**Consultation Response from KC,
Highways Development Management**

2024/90792 Former Whiteley Engineering Works Site, St. Peg Lane, Cleckheaton, BD19 3SH

Use of land for assembly and storage and fit-out of acoustic containers of container-based generator units with reinstatement of access, erection of security fence and siting of cabins

Date Responded: 5-6-2024.

Inbound Manoeuvre (Low Loader)

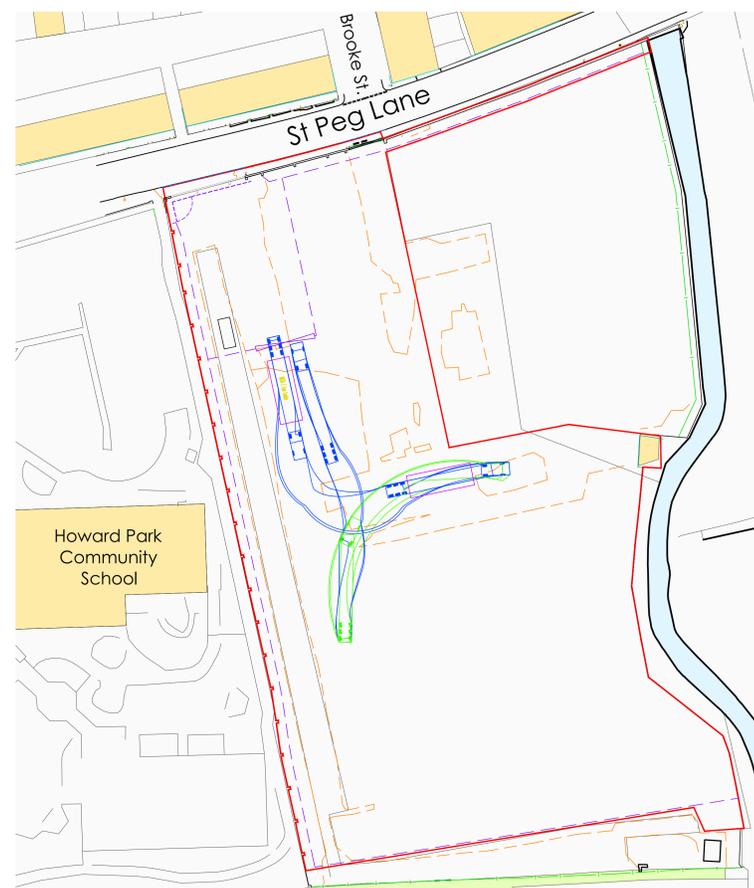
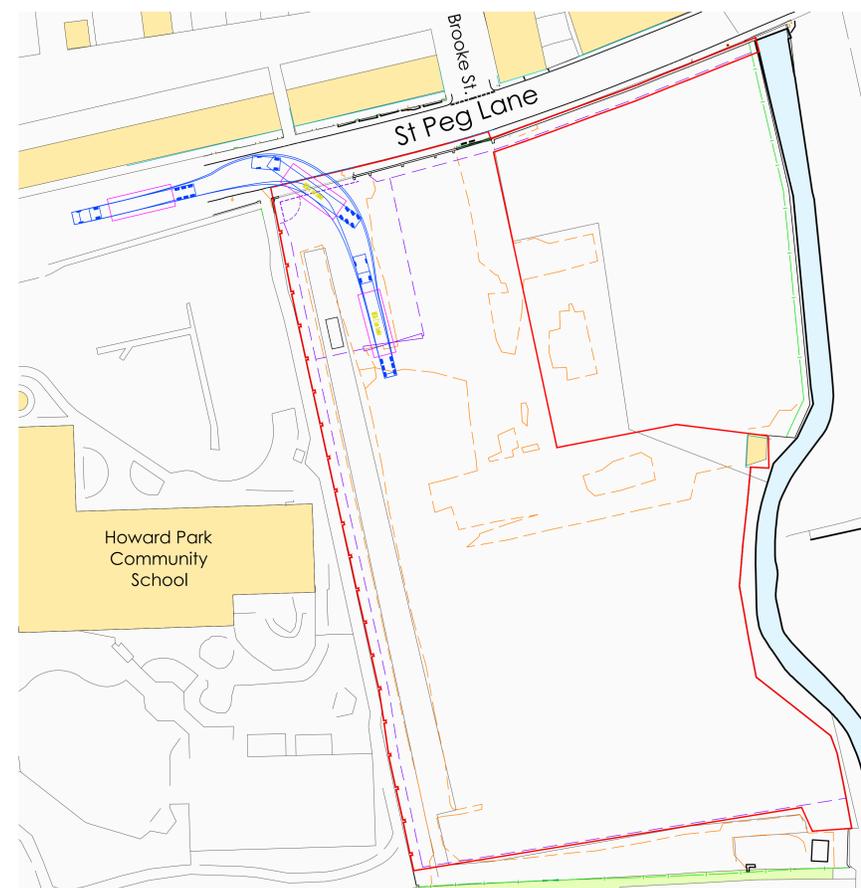
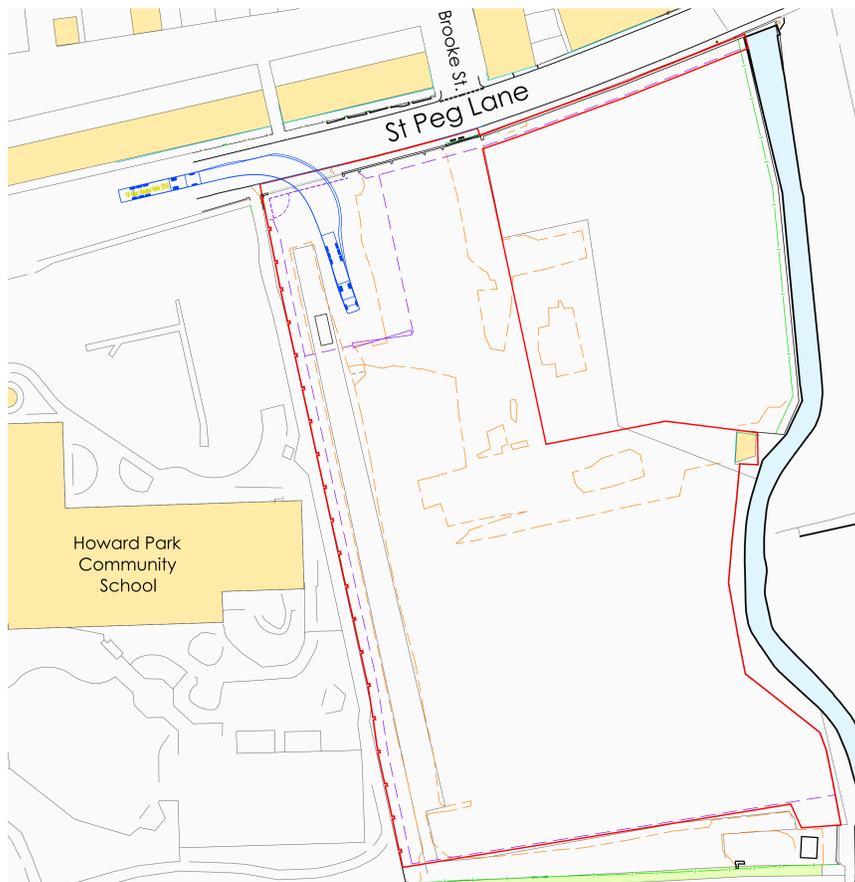
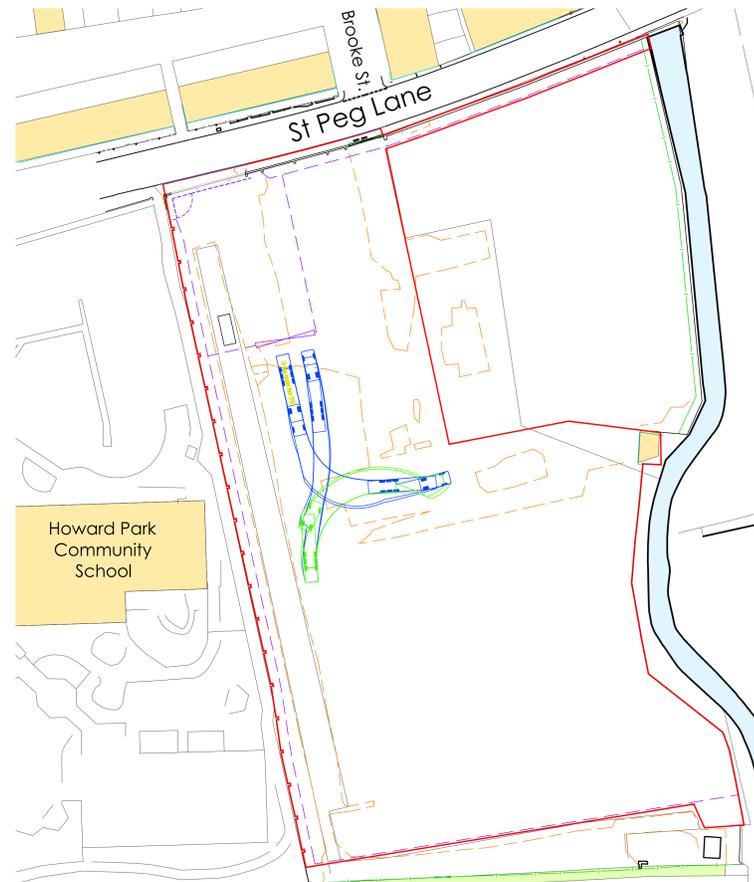
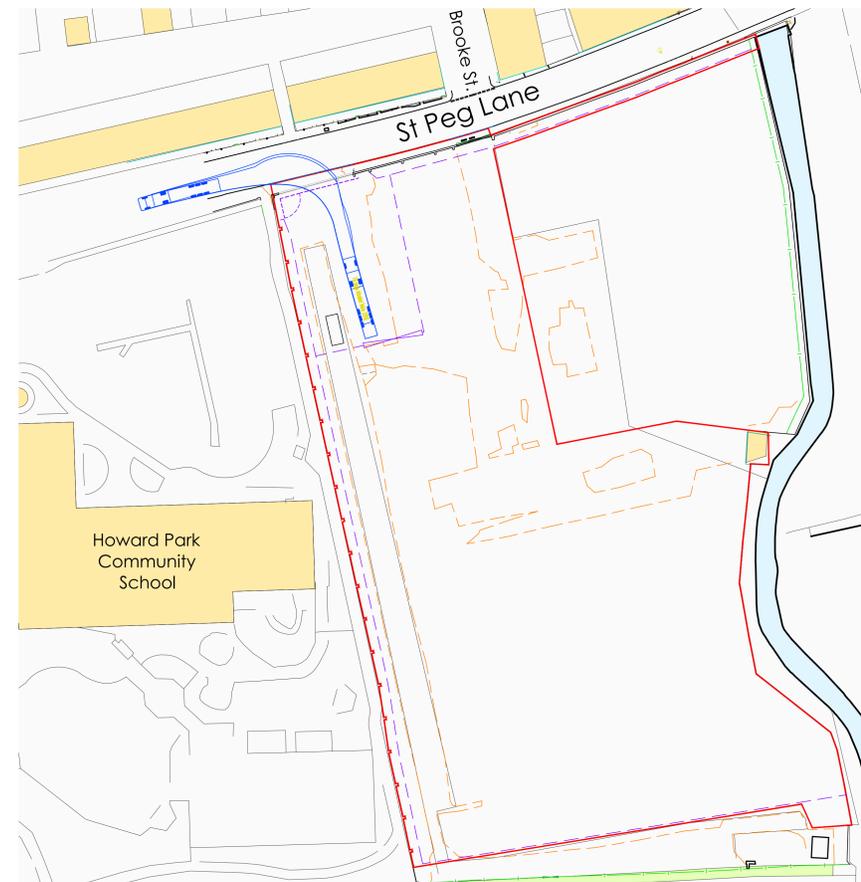
- 2, No details of the proposed sight lines from the proposed access onto St Pegs Lane are provided. 2.4 x 43 m sight lines need to be shown.
- 3, Can the applicants explain how the proposed gates are to operate HDM would not want to see vehicles waiting on St Pegs Lane.

- 5, Can the applicants be asked to provide details of all anticipated vehicles movements into and out of the site.
- 6, Details of the proposed staff parking areas should be provided.

Drawing Title:
 Proposed Site Plan

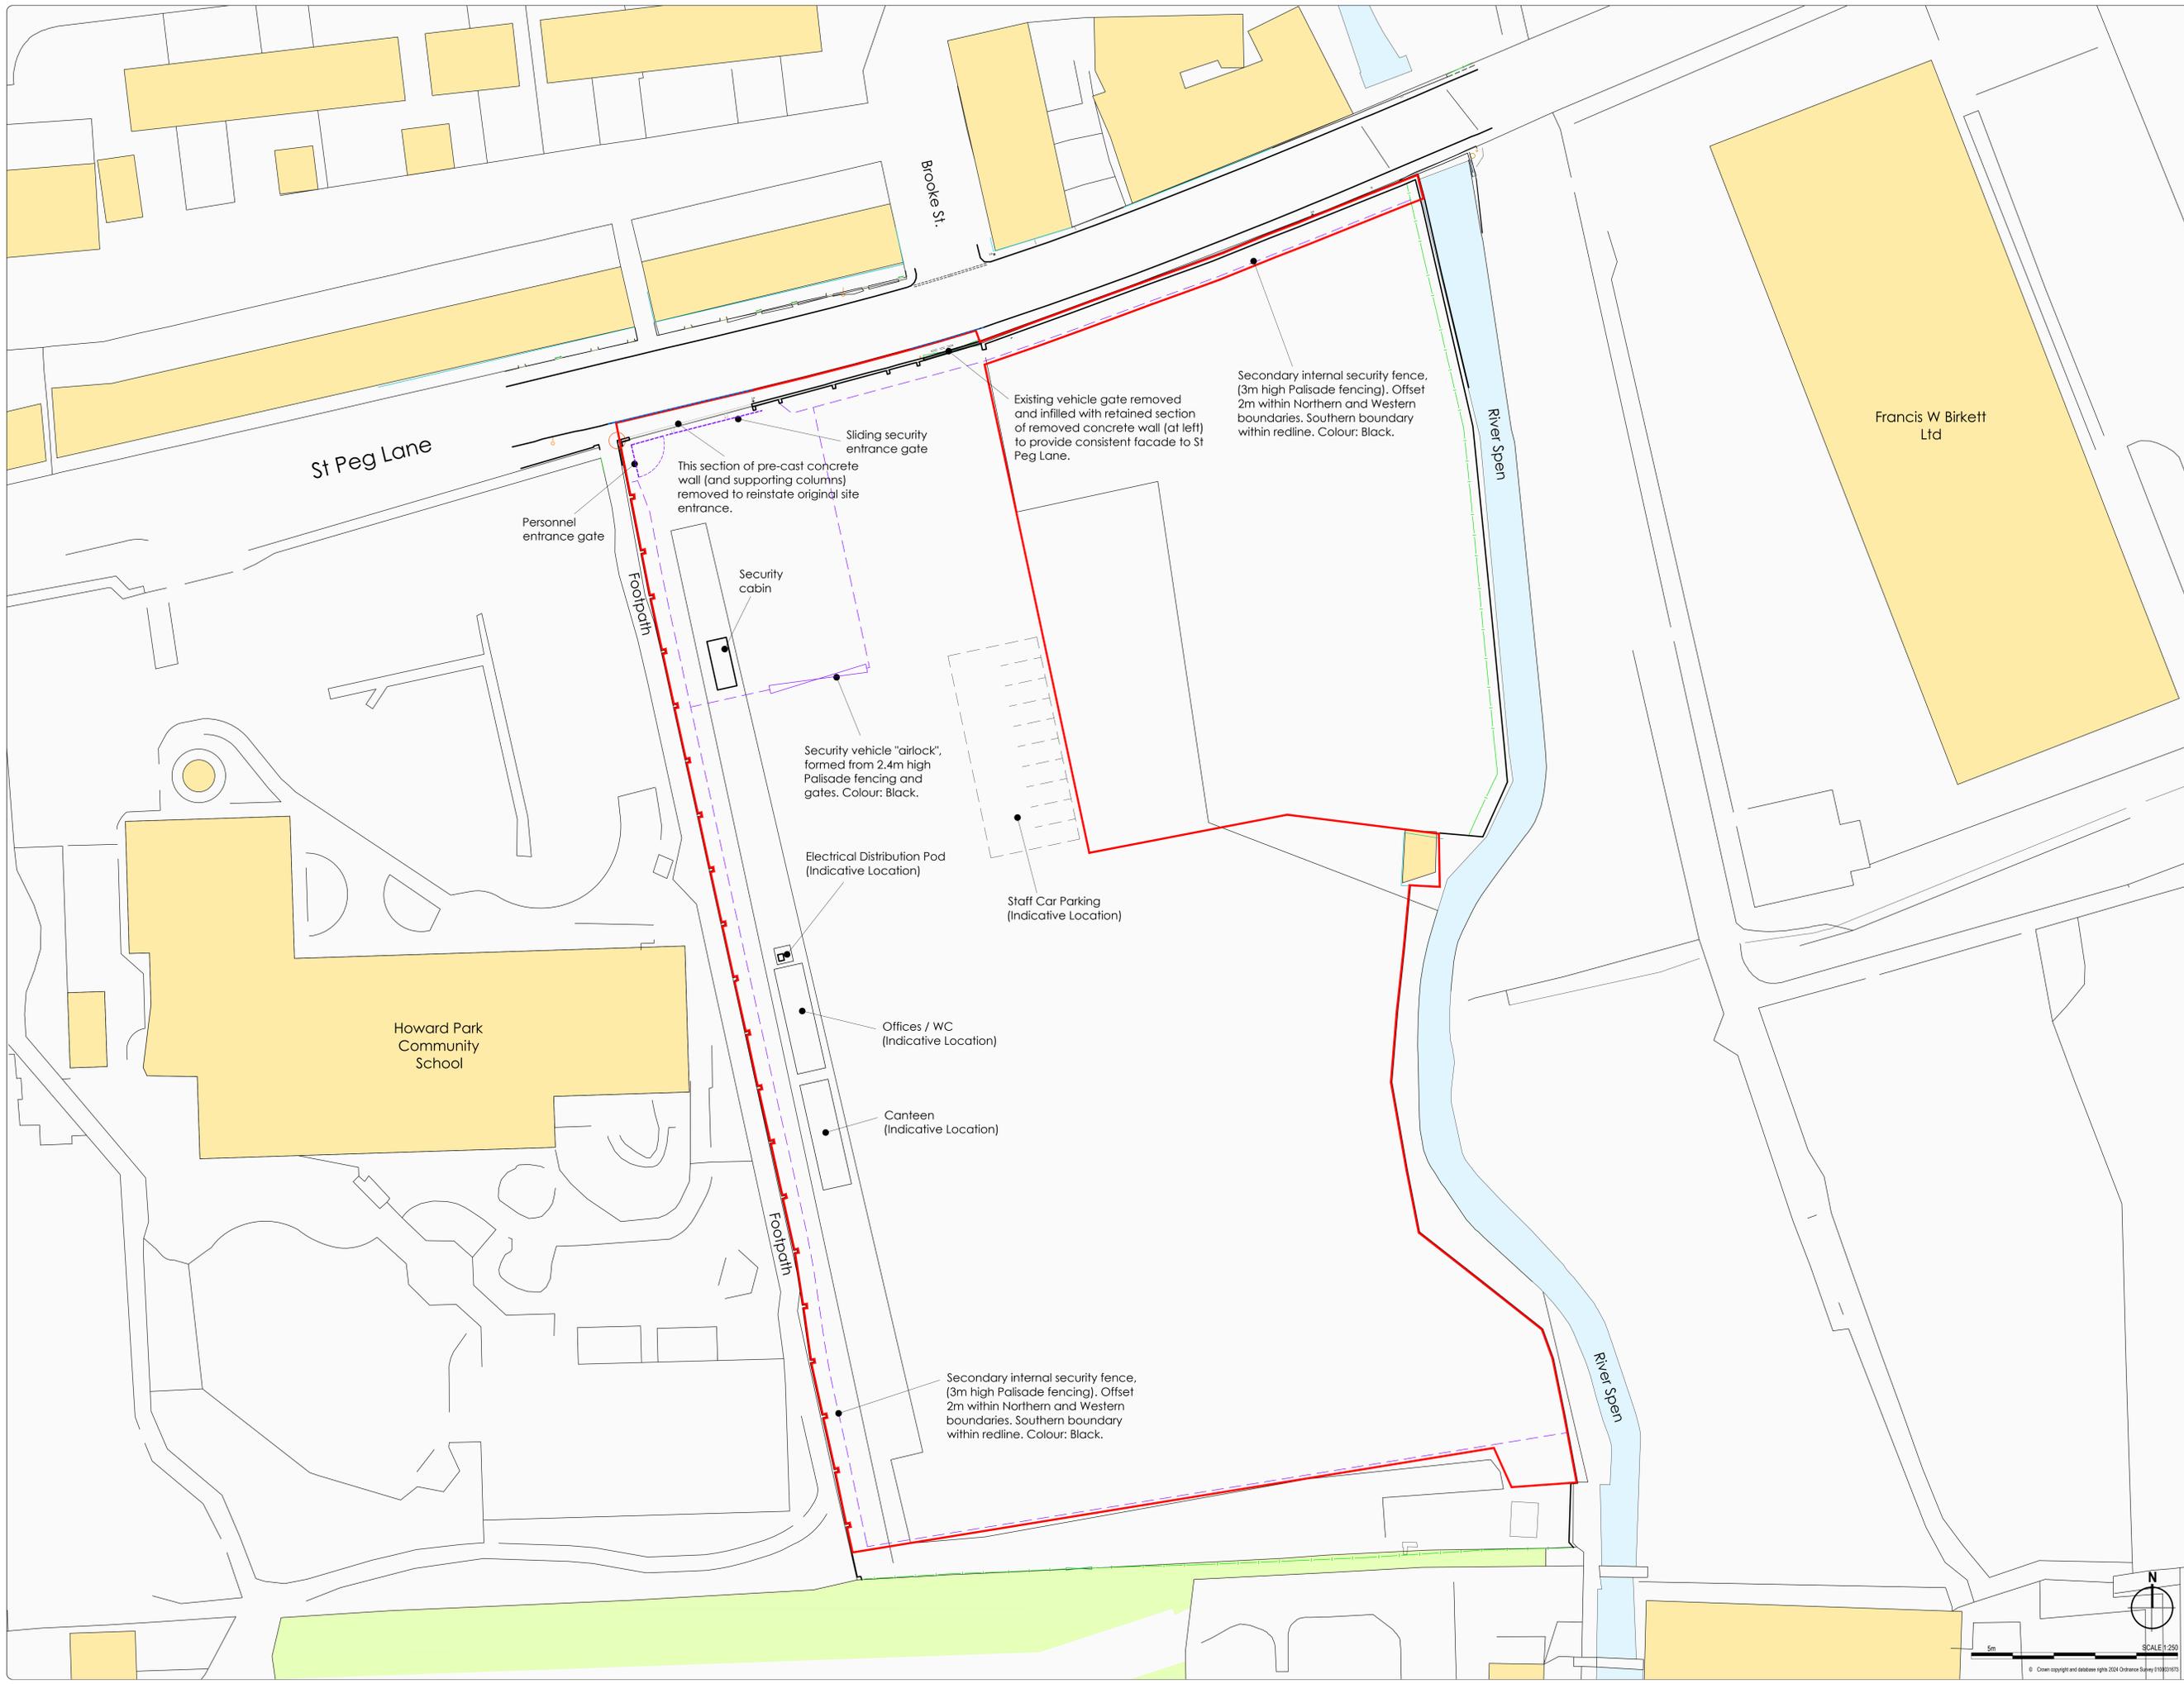
- 1, The footway to the site frontage is narrow at approximately 1.2m and should be shown to be widened to 2.0m to the full site frontage to improve pedestrian facilities in the area including to the adjacent school.
